From: [REDACTED]
To: [A303 Stonehenge](#)
Cc: [REDACTED]
Subject: Stonehenge Bored Tunnel Extension Comment on Re-determination Document 4.7, 4.10.3, 4.10.4
Date: 29 July 2022 16:37:43

**Stonehenge Bored Tunnel Extension: Comment on Re-determination Document 4.7:
4.10.3, 4.10.4**

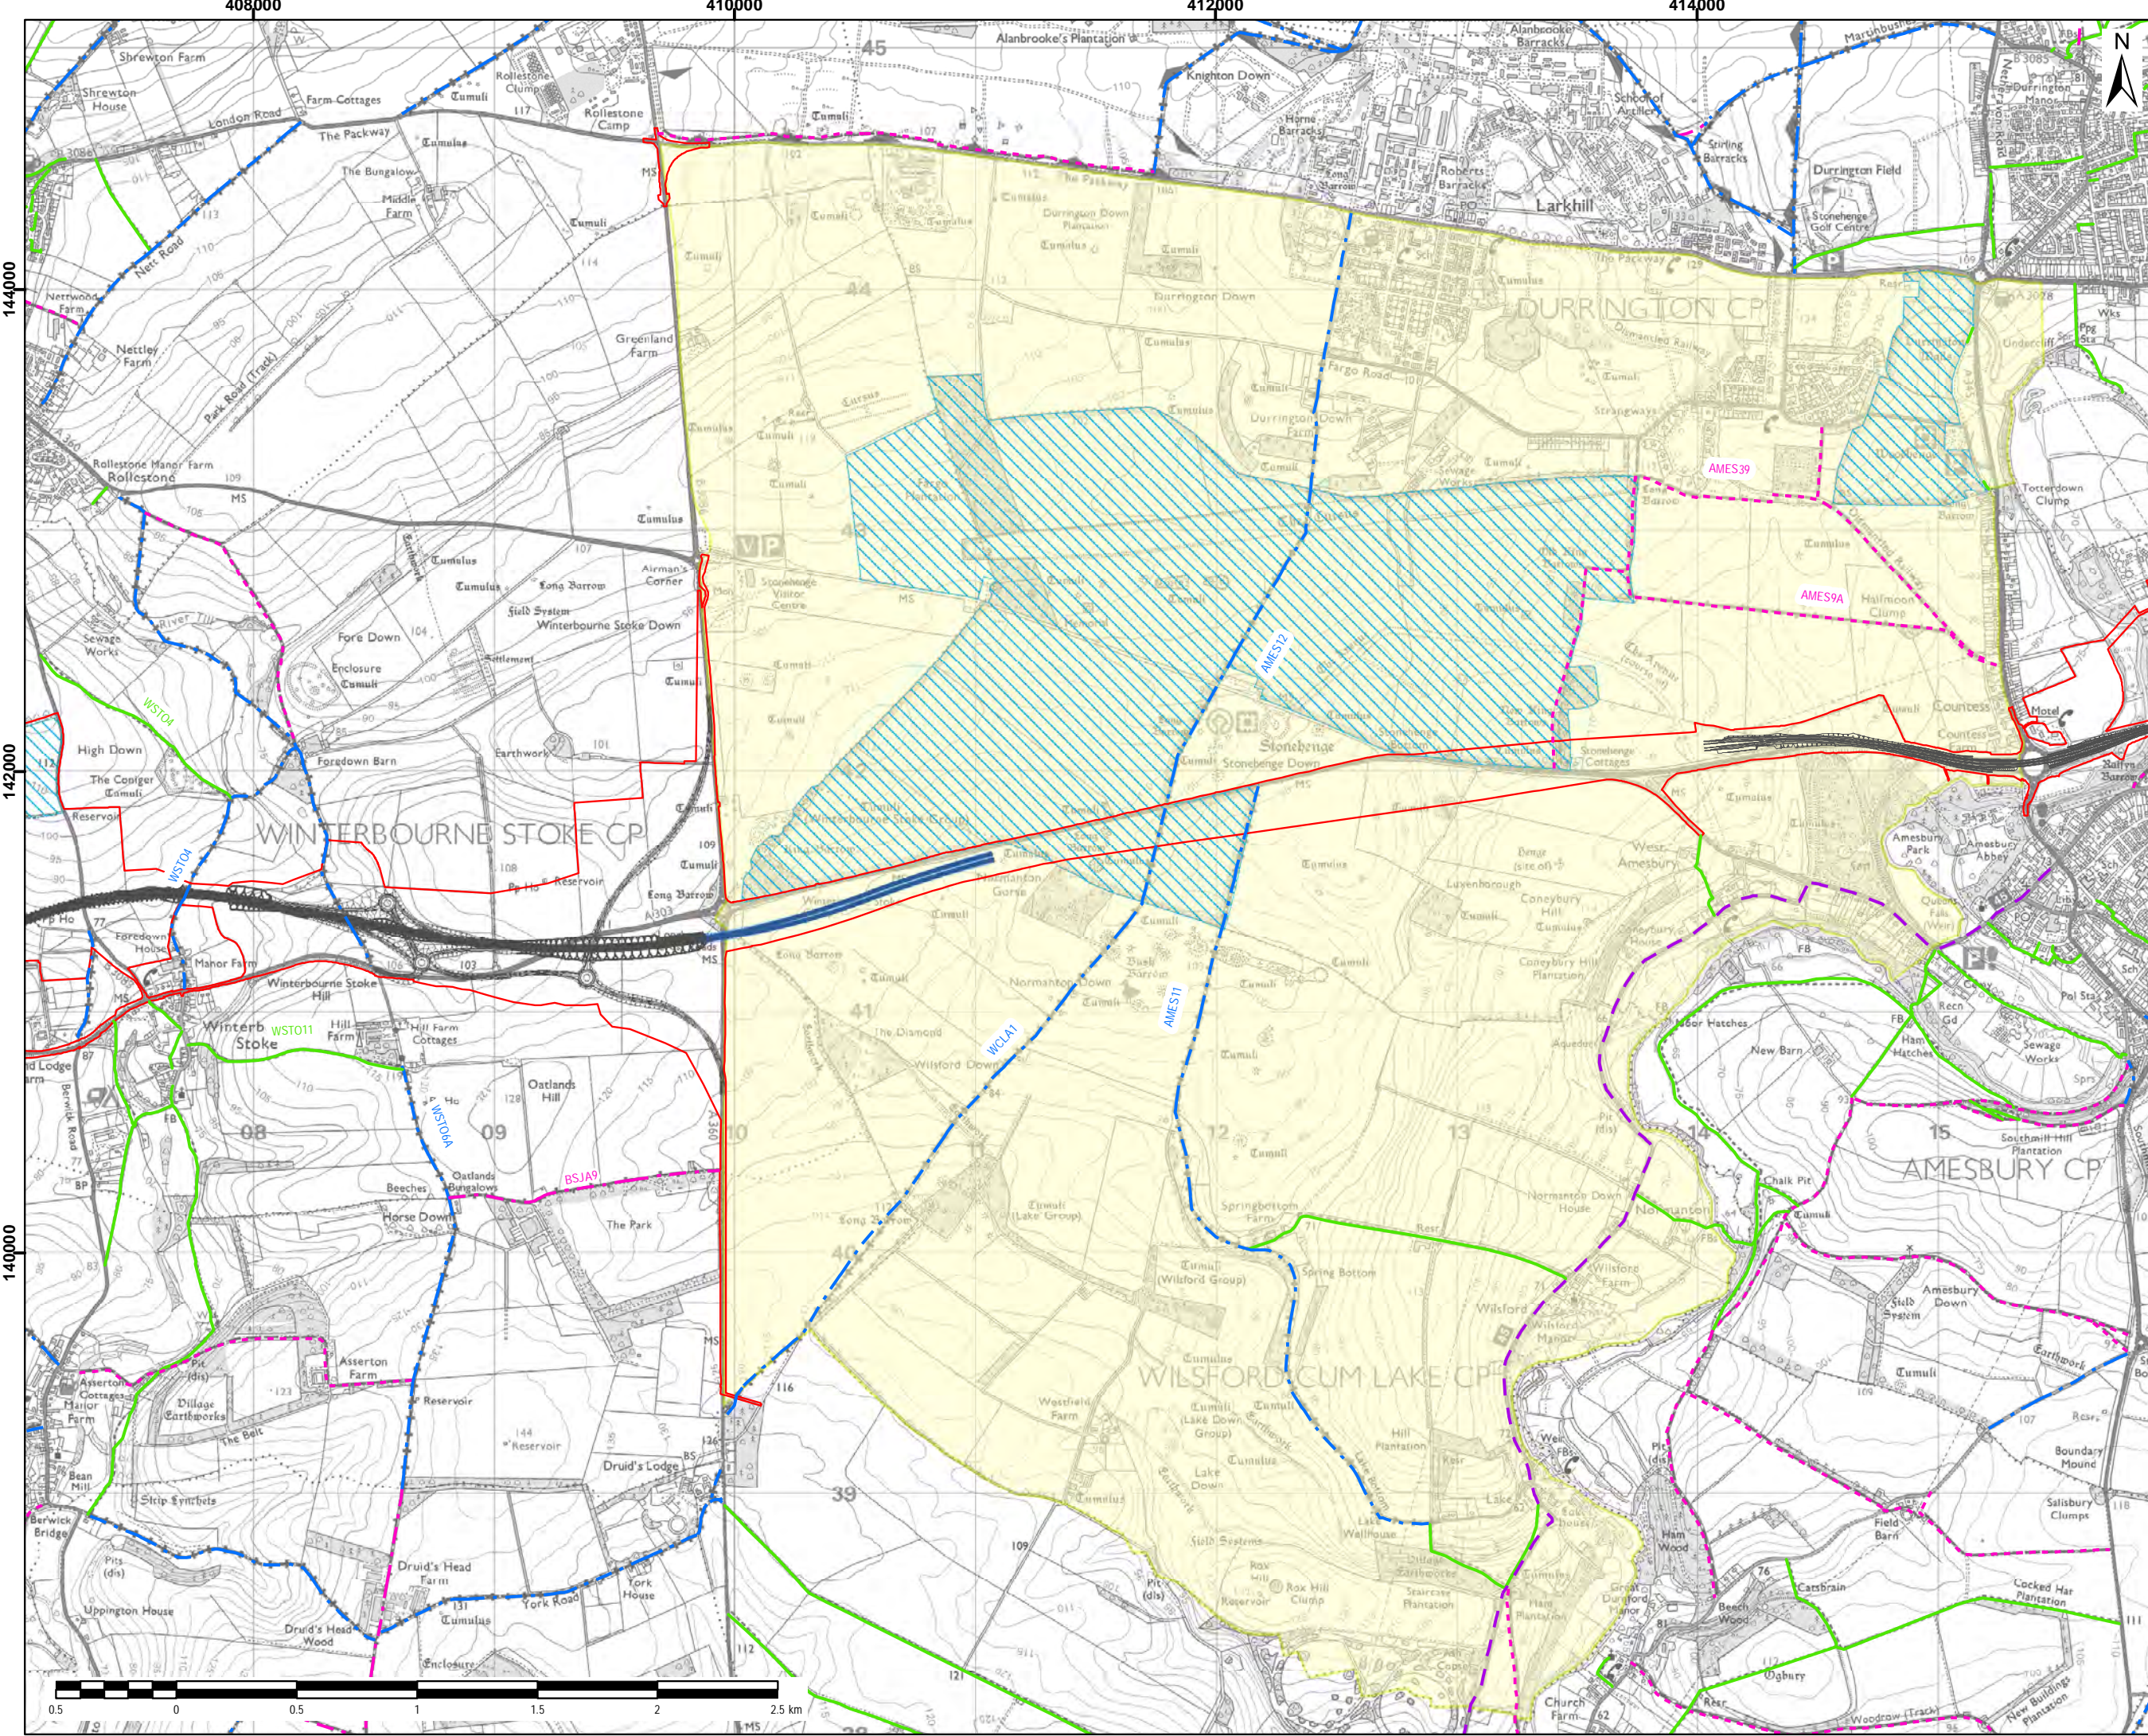
In 4.10.3 it is stated that Byway WSTO6B will be closed to users during construction. The B3083 is not a suitable alternative journey for horse riders, very vulnerable road users, who face increased levels of traffic on this road during construction. No mention is made of the existence of Byway WSTO4 - which should be left open to provide a suitable alternative route to WSTO6B during the construction period.

In 4.10.4 it is stated that the Bored Tunnel Extension would provide a diversion for WSTO6B, directing the Byway south west under the Till Viaduct and south to the existing A303.

I would like an assurance that the emergence of this route on to the old course of the A303 is at a safe point for NMUs, particularly horse riders, to enter and exit.

I note that the Bored Tunnel Extension would also provide a new bridleway along the north of the A303 between the Alternative Longbarrow Junction and Winterbourne Stoke. I welcome this new bridleway as an important connection for horse riders, and would like assurance that this new bridleway would (A) be registered as a bridleway on the definitive map, and (b) that it will connect safely directly to the course of the old A303 east-west (to be designated a restricted byway).
